SSD-10340 - Redevelopment of Fort Street Public School

Thank you for the opportunity to comment upon the Fort Street Public School State Significant Development.

Figure 1 Phase 1 Student Drop-off and Pick-up

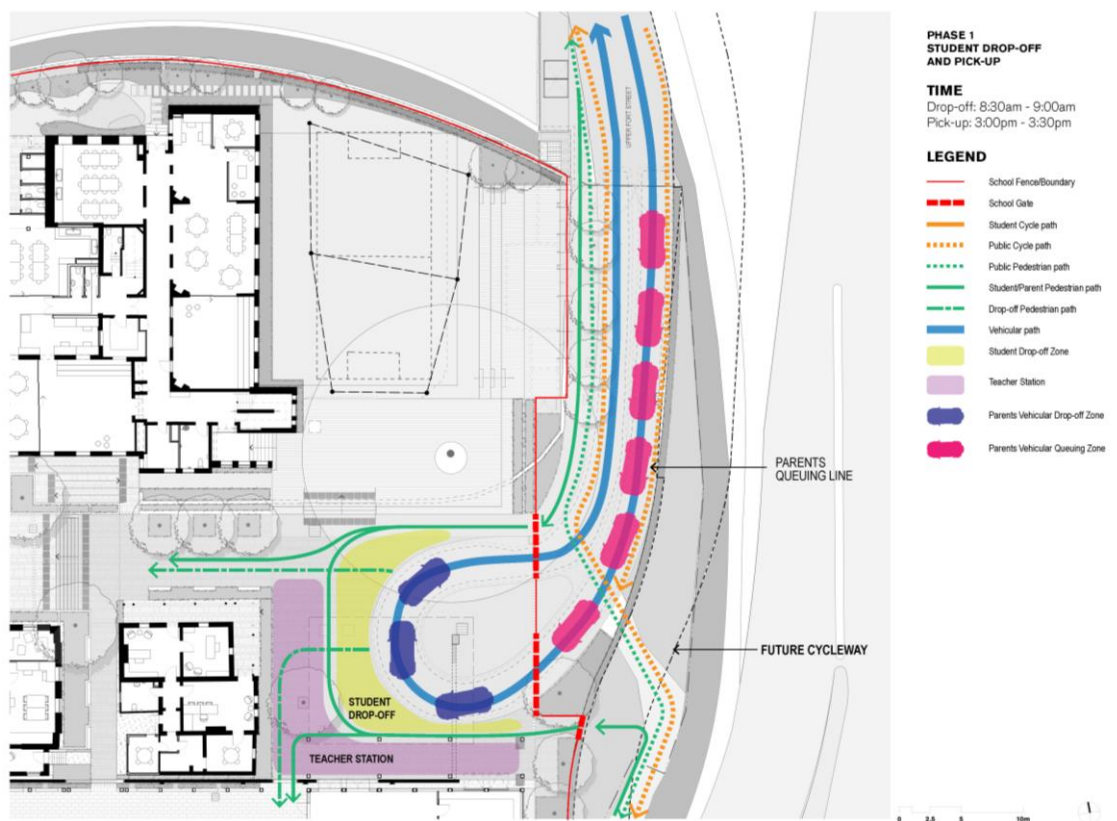
1. *The heavy reliance on good behaviour and considerate driving.* The proposed school traffic queue in the afternoon with dedicated passing bays will require some education of the school community and also staff at the Trust to understand this unique traffic situation and ensure the smooth and safe movement of traffic in the peak periods. It is a concern that irregular users, such as visitors to the school or Trust, will not be familiar with the etiquette, increasing the risk of a traffic incident.

Figure 7 Cycleway open – drop-off and pick-up access

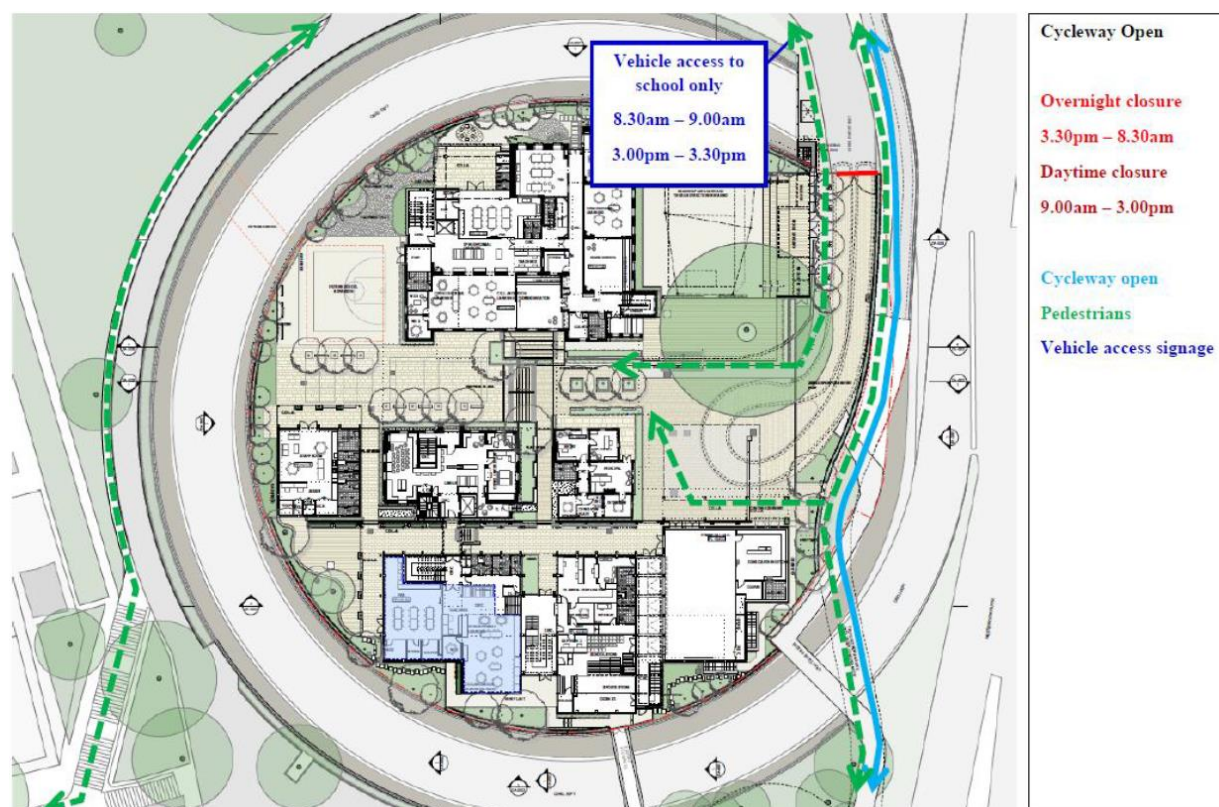
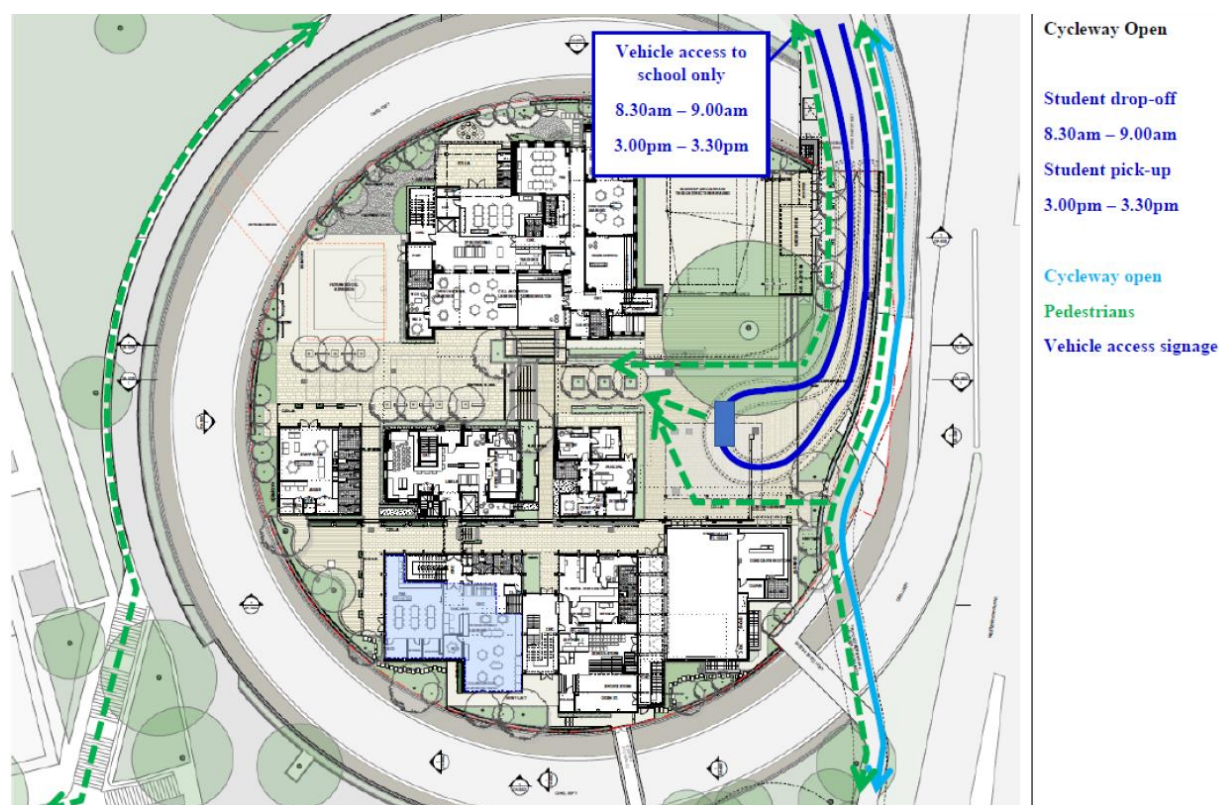
3. *The proposal to create a shared vehicle/pedestrian zone to the private National Trust roadway.* This is a single lane road, and two vehicles cannot pass. The boom gate at the entrance of the Trust, needed to prevent city commuters unrelated to the Trust parking at the site, results in some morning traffic needing to reverse the entire length of this curved road. **This is not compatible with a shared pedestrian road**, particularly one that may be used by children unaccompanied by an adult.

4. *Impact of the new cycle path on the Trust.* Several of the perspective drawings of the completed Fort Street Public School expansion illustrated the vehicle access to the Trust land terminating at the eastern end of the current carpark (see Fig. 1). Currently, there is a road around the eastern end of the National Trust Centre (see Fig. 2) providing vehicle access to the southern side, and overflow parking options. It is hoped this is just an error that was carried through from an earlier survey and access to the Trust Centre's loading bay and plant room will not be impeded once the bicycle path is complete.
